Subject: FW: Planning Consultation on LU/120/18/DOC and LU/155/18/DOC

This application is looking for the discharge of Condition 15 of application LU/120/18/DOC

18
Site Address: Directors Cottage Toddington Lane
Littlehampton BN17 7PP
Description of Works: Approval of details reserved by condition imposed under LU/249/17/PL relating to conditions 3-Construction Management Plan, 5-visibility splays, 15- landscape scheme & 16-schedule of materials & finishes.

Drawing: **SITE PLAN**

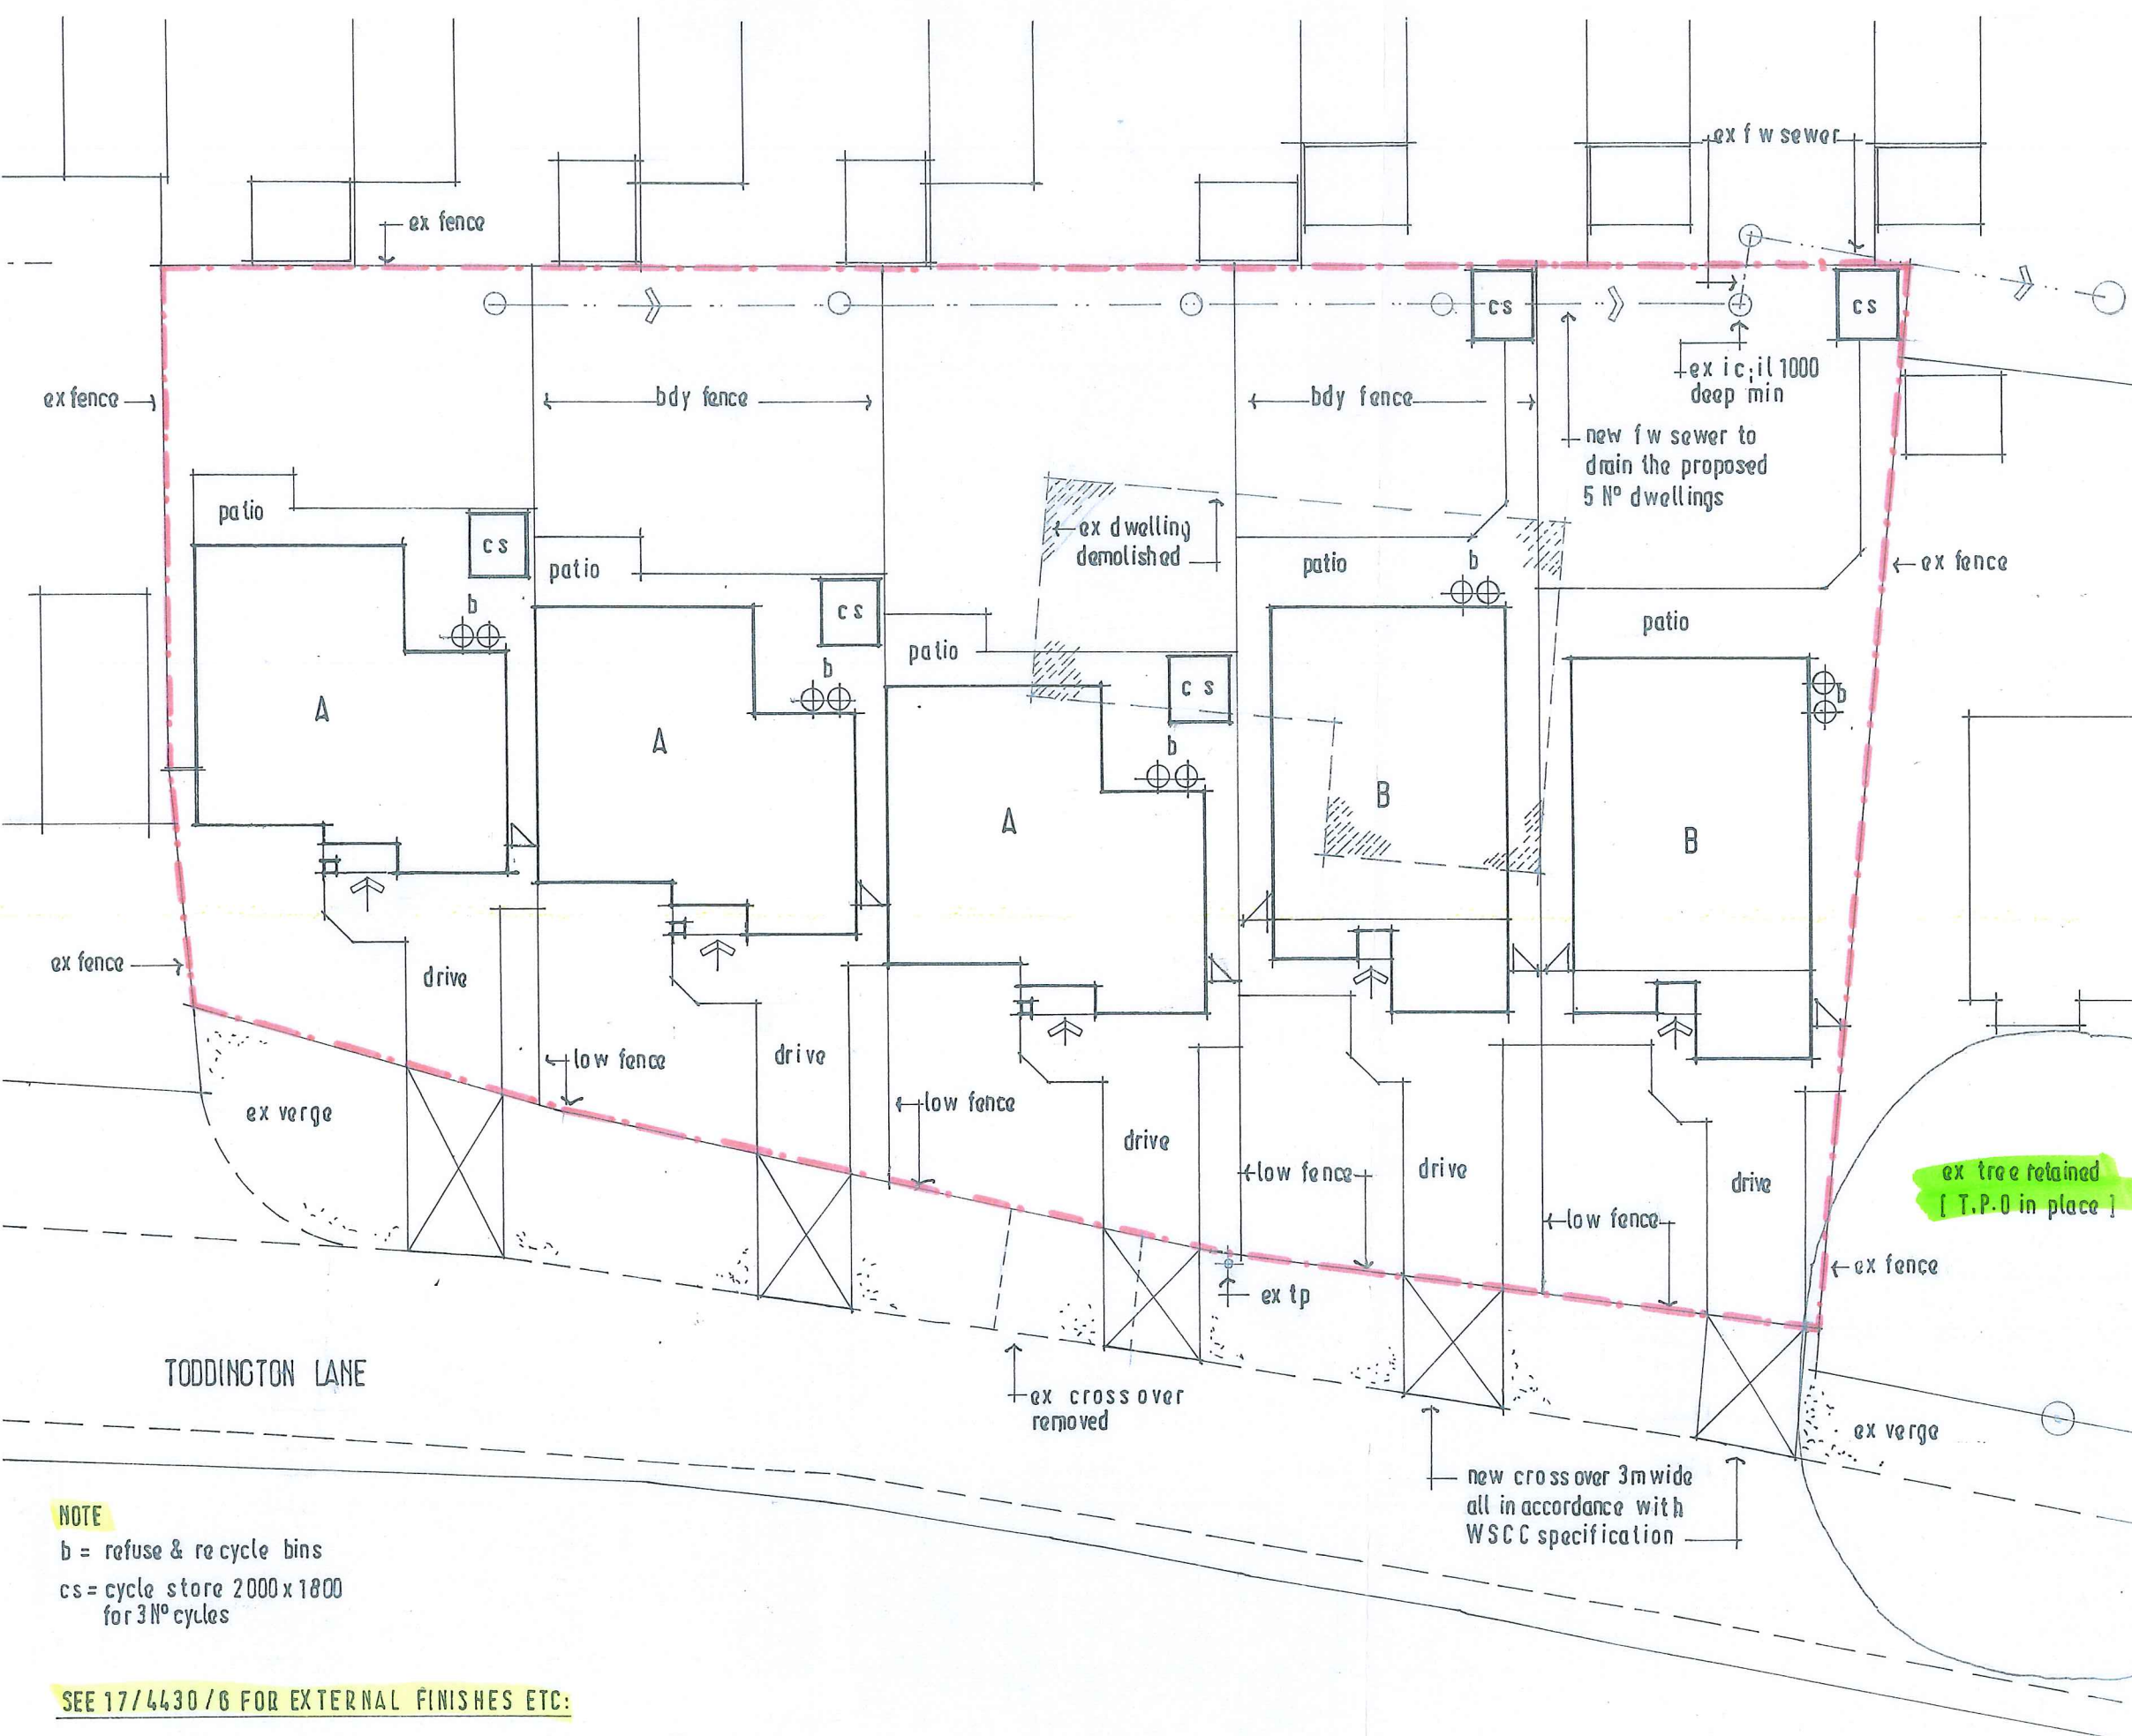
This application lists Condition 15 however no further details have been submitted re Landscape scheme and the information contained within DWG 17/4430/05 and 17/4430/16 is insufficient in detail as not providing detail in plan form of proposed trees and shrubs detailing actual quantities, species choice planting density and size at time of planting. As my previous comments, greening of new development is required to ensure that the development is fitting to location, aiding in good design, providing screening to adjacent dwellings where required and encouraging biodiversity within the site.

There is insufficient information submitted and therefore I would **not recommend the discharge of Condition 15** on application LU/120/18/DOC imposed under LU/249/17/PL until further detail is submitted for approval.
